PLANNING DEPARTMENT – Development & Building Services

RE: **Drainage Management Plan (DMP) Update** – incl. Bosque School Area Ponds
SE Corner of Coors & Montañó NW P.E. Stamp: 10/31/12 File # **E12-D015**

DMP Update - Bosque School Area

**DRAWING NAME**  
 POND 'A'  
 GRADING  
 PLAN

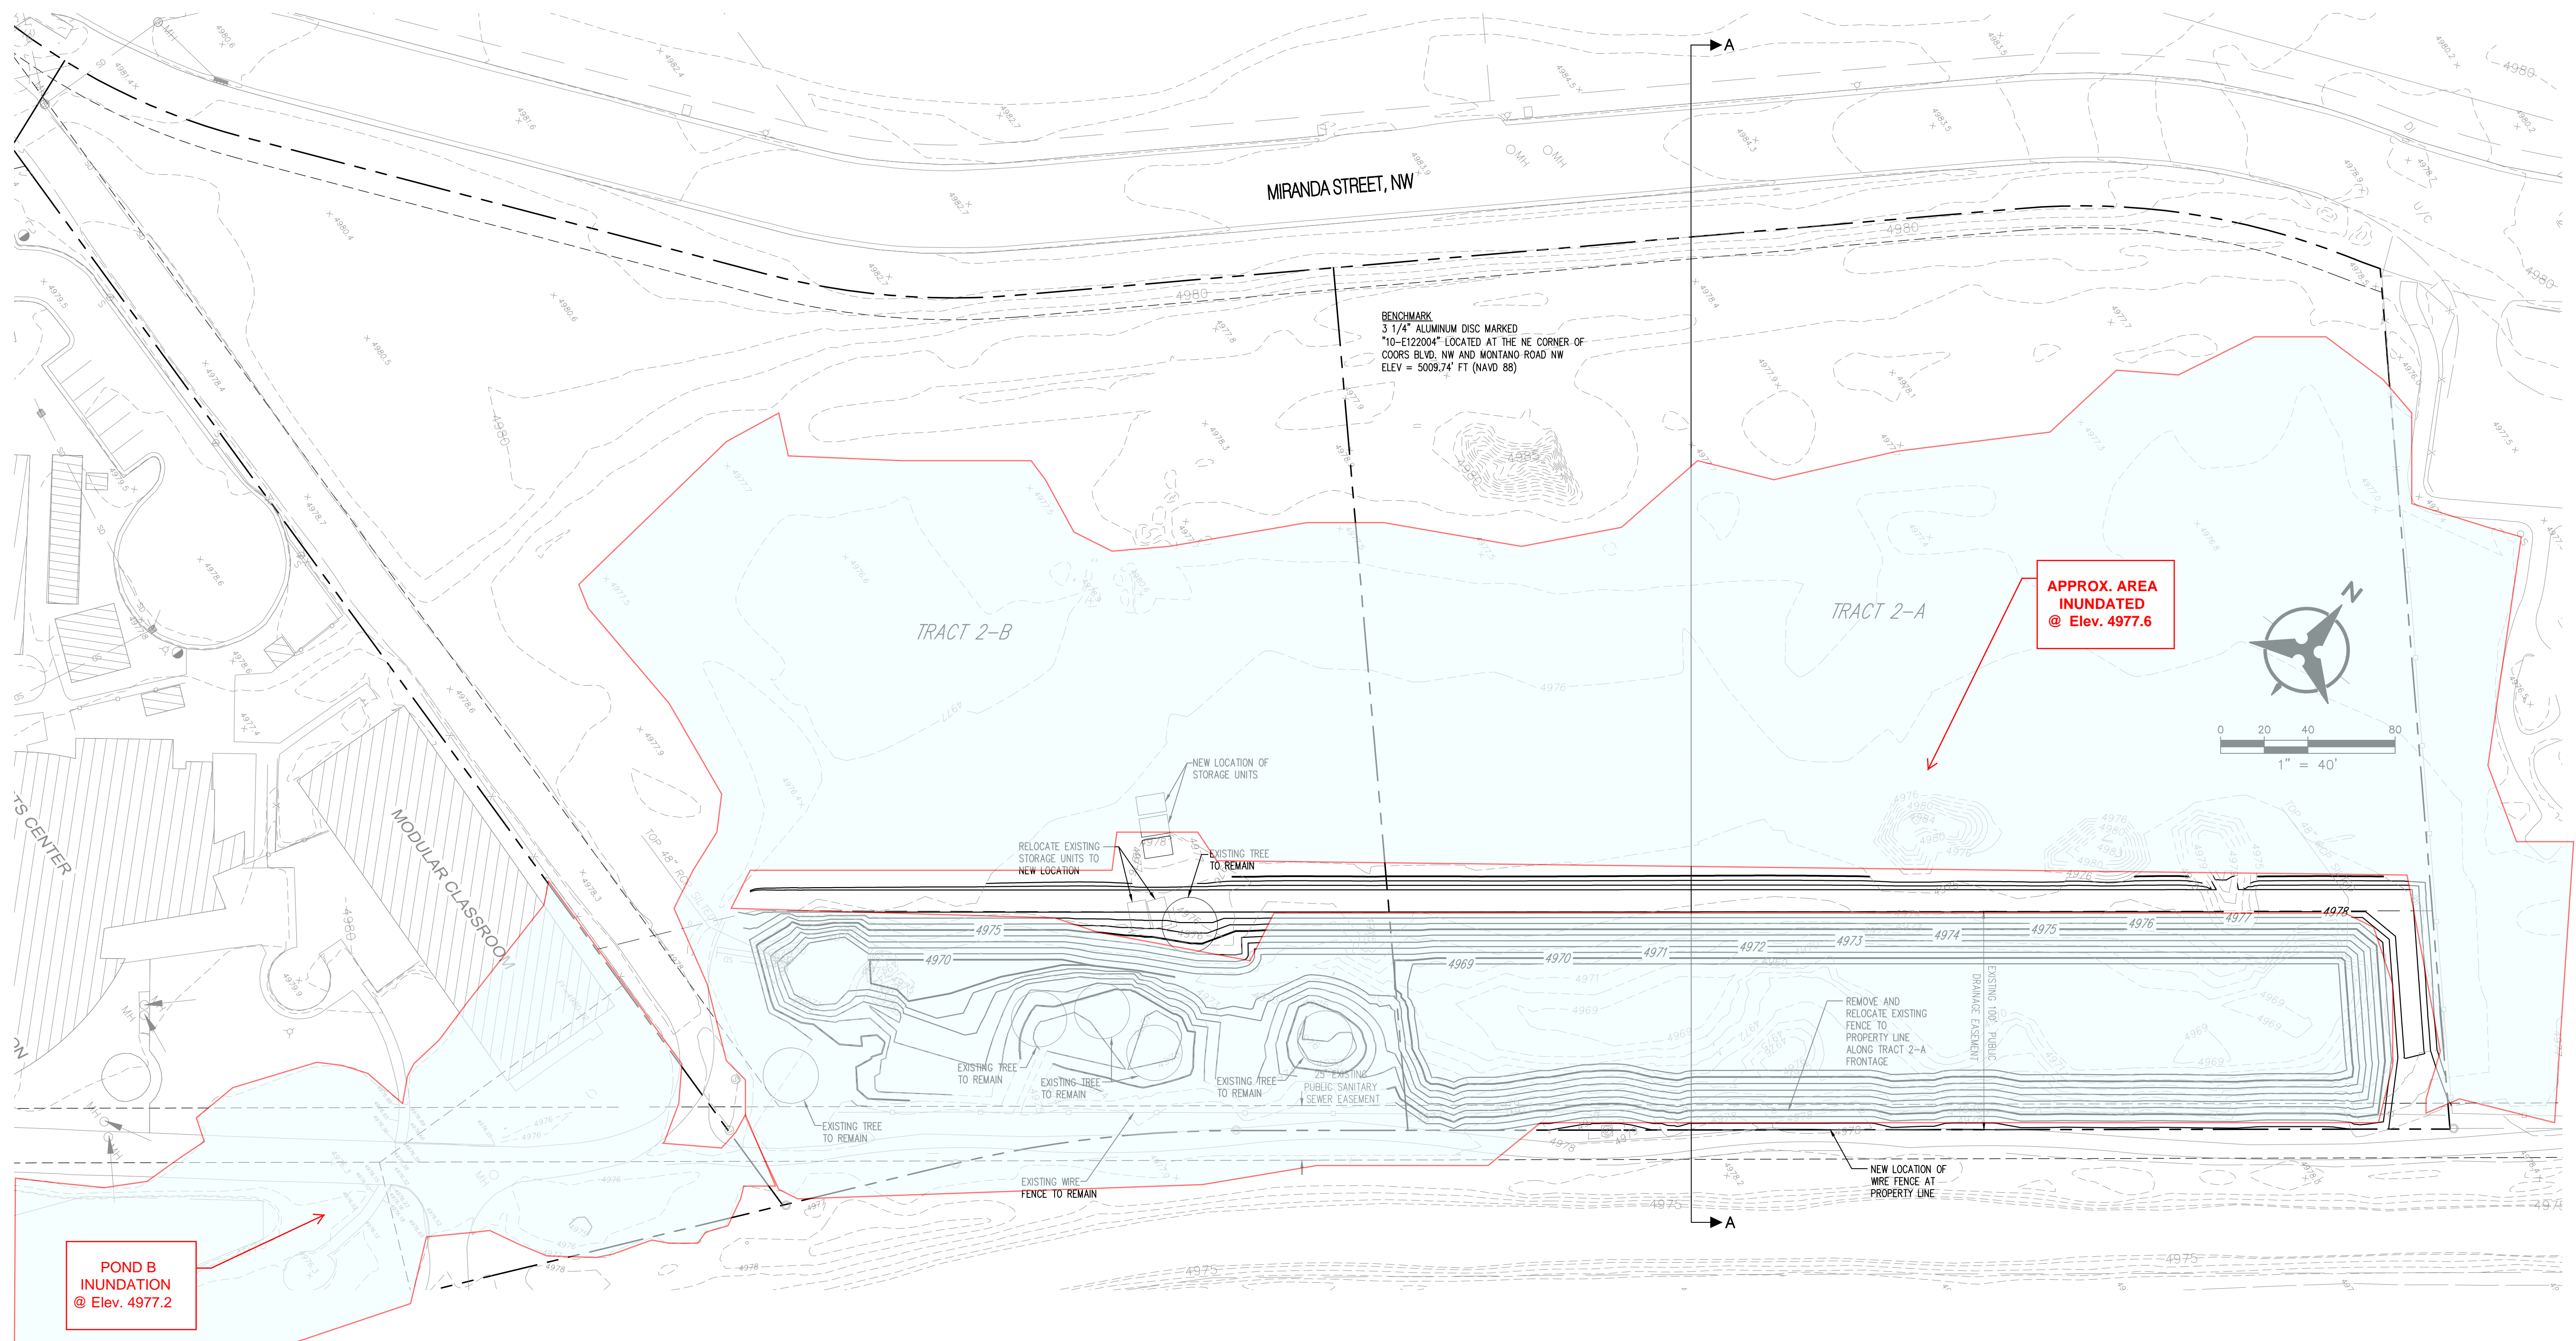
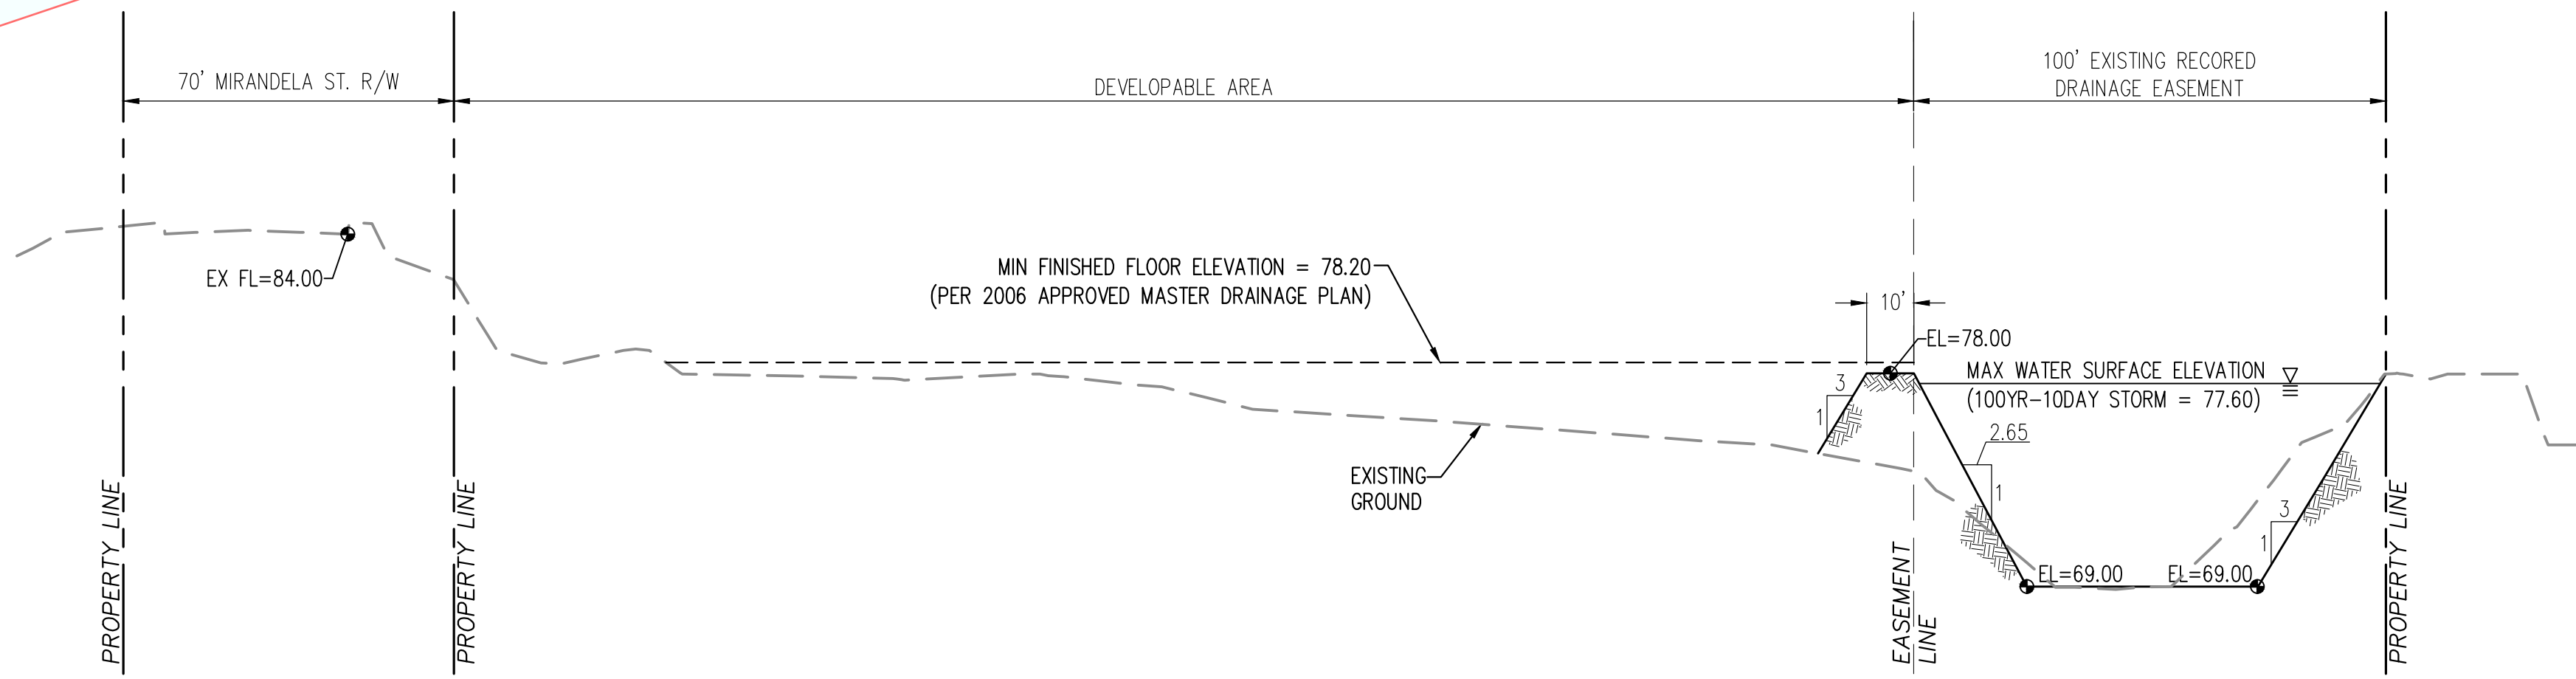
10. We require a separate, larger scale Grading Plan for any proposed grading at Pond A (or Pond B) and the spillway to Pond B. Section E-E should include a water surface elevation, representative of the standing water observed within the pond. Spring 2012 photos show that level to be roughly 2 feet above the invert of the 60" inlet line at the south end of Pond A. Pond volume calculations cannot include any capacity below the observed, standing water surface.
